Arun District Council
Arun Civic Centre
Maltravers Road
Littlehampton
West Sussex BN17 5LF
Planning & Building Control General Enquiries
Tel: (01903) 737756 Fax: (01903) 730442
Dx: 57406 Littlehampton
Minicom: 01903 732765
e-mail: planning@arun.gov.uk
website: www.arun.gov.uk/planning

Application No: AW/220/20/HH
Site Address: 96 Rose Green Road Aldwick PO21 3EQ
Description of works: Conversion of existing bathroom to a utility room and existing study to a new bathroom, inserting new hot and cold water pipes and soil pipe. This application affects the setting of a Listed Building.

Thank you for your internet representation made on 29th September 2020 which has been recorded as no objection with the comments as follows:

DRAWING TITLE
 EXISTING & PROPOSED BATHROOM LAYOUTS

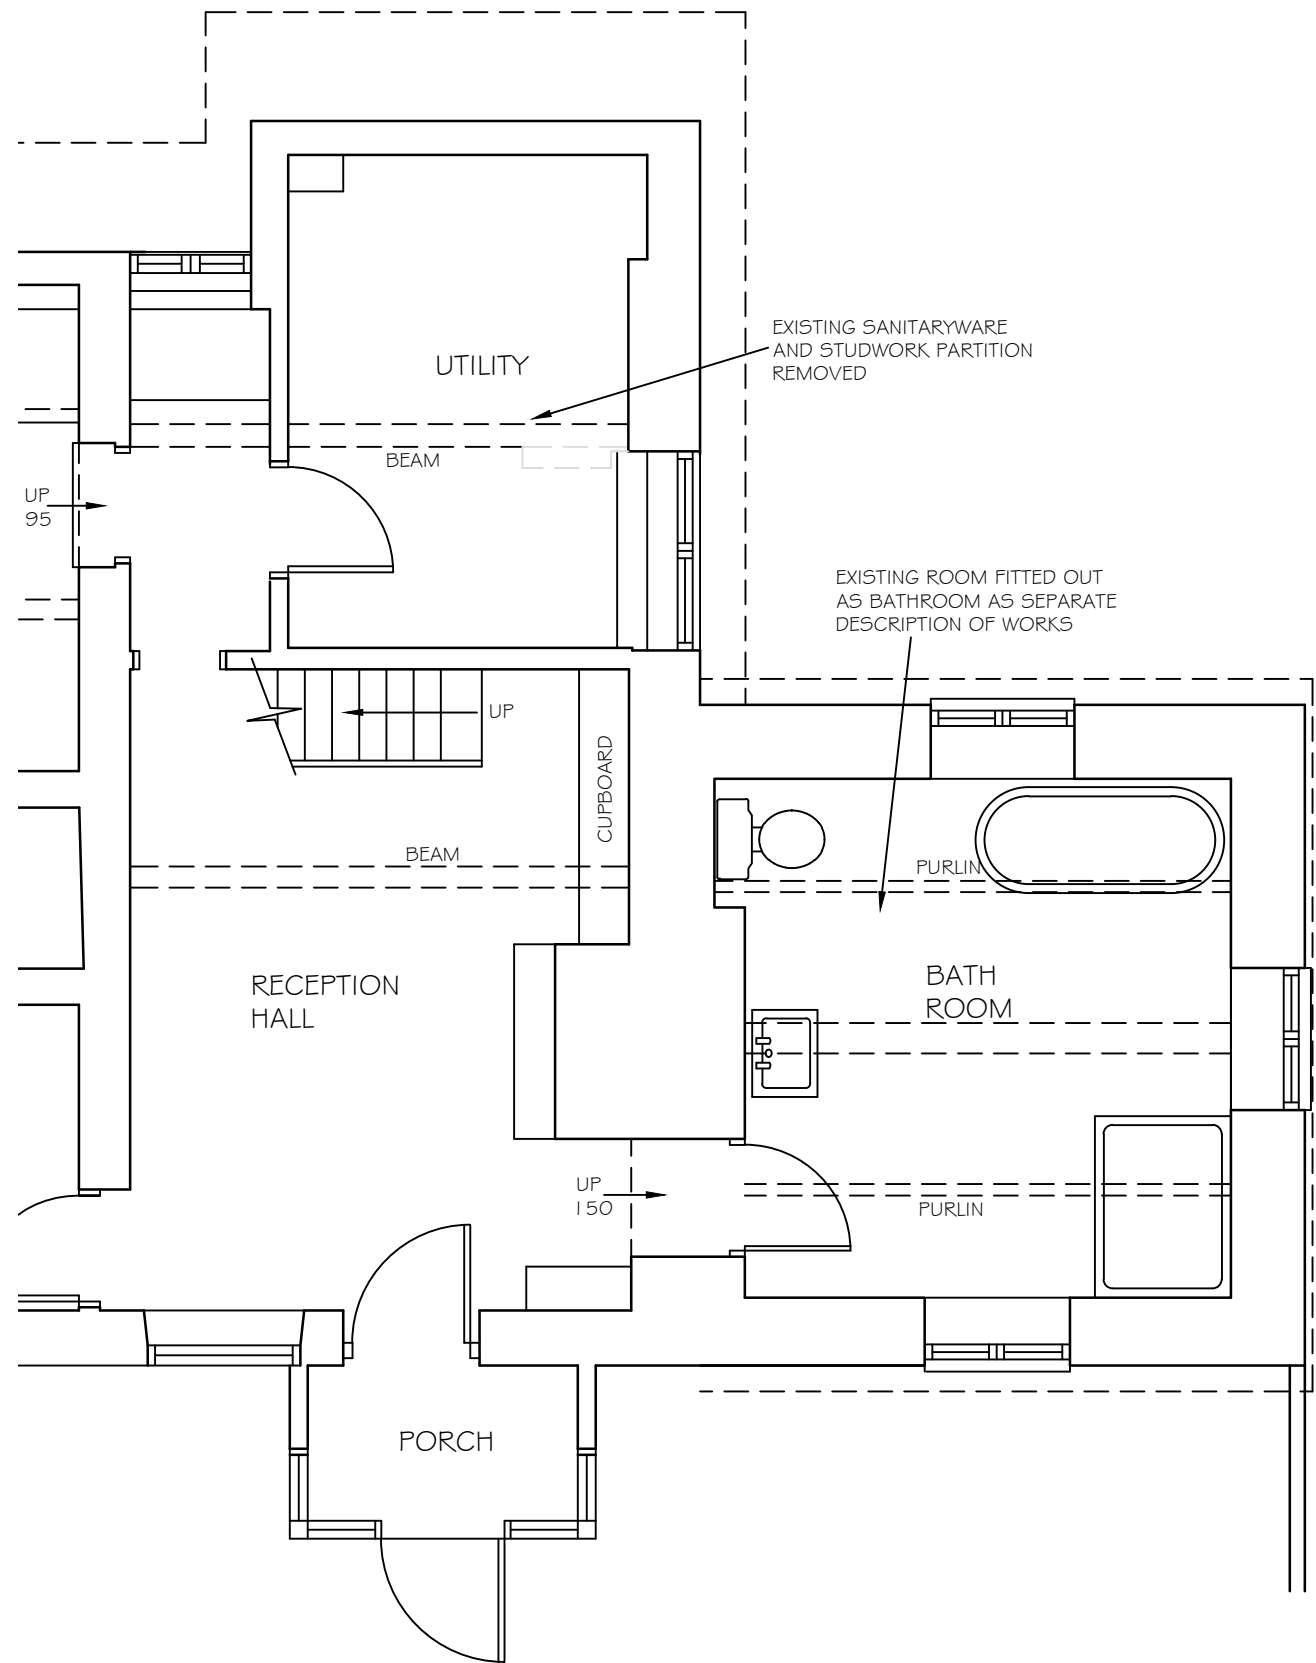
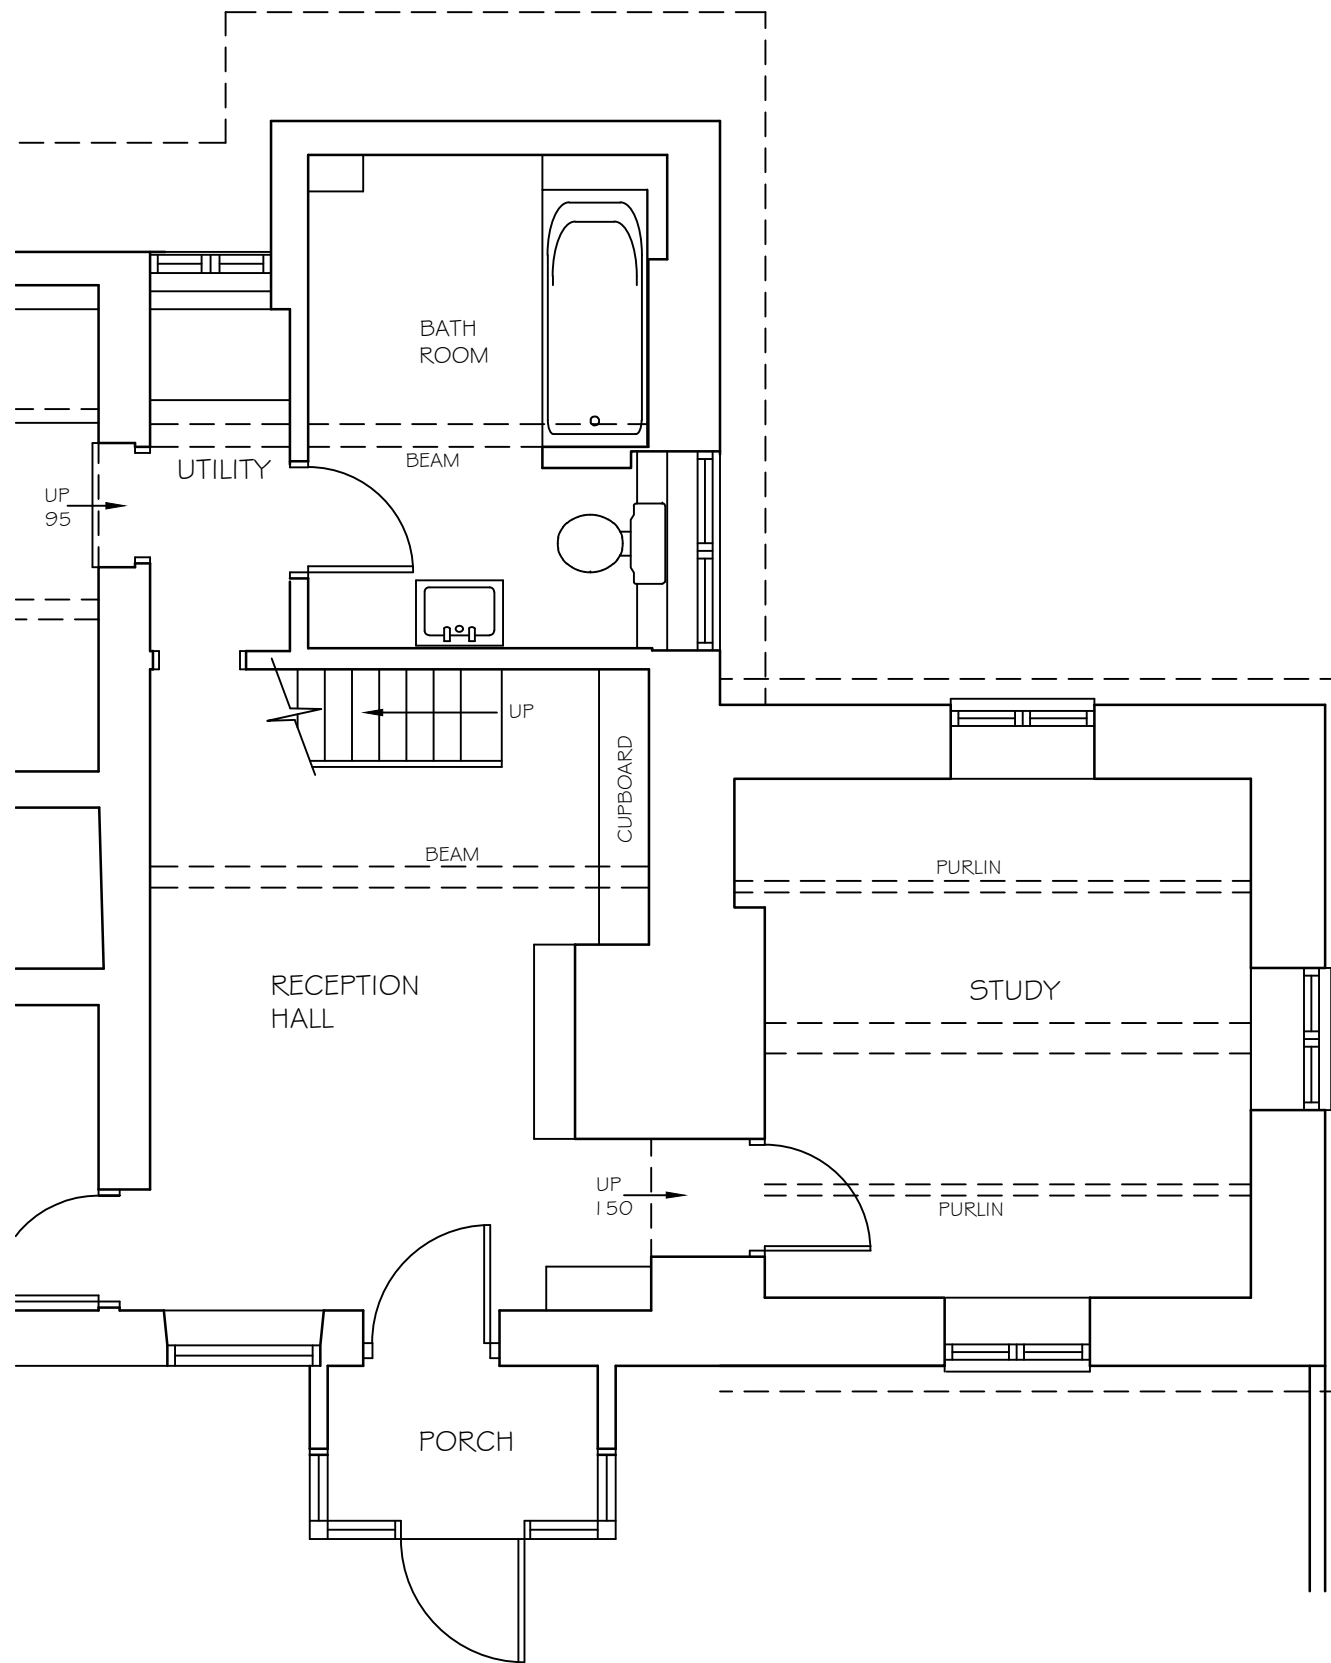
Members have no objection to the application, provided that the pipework used is of heritage level and the breach in the wall is made good using traditional materials.
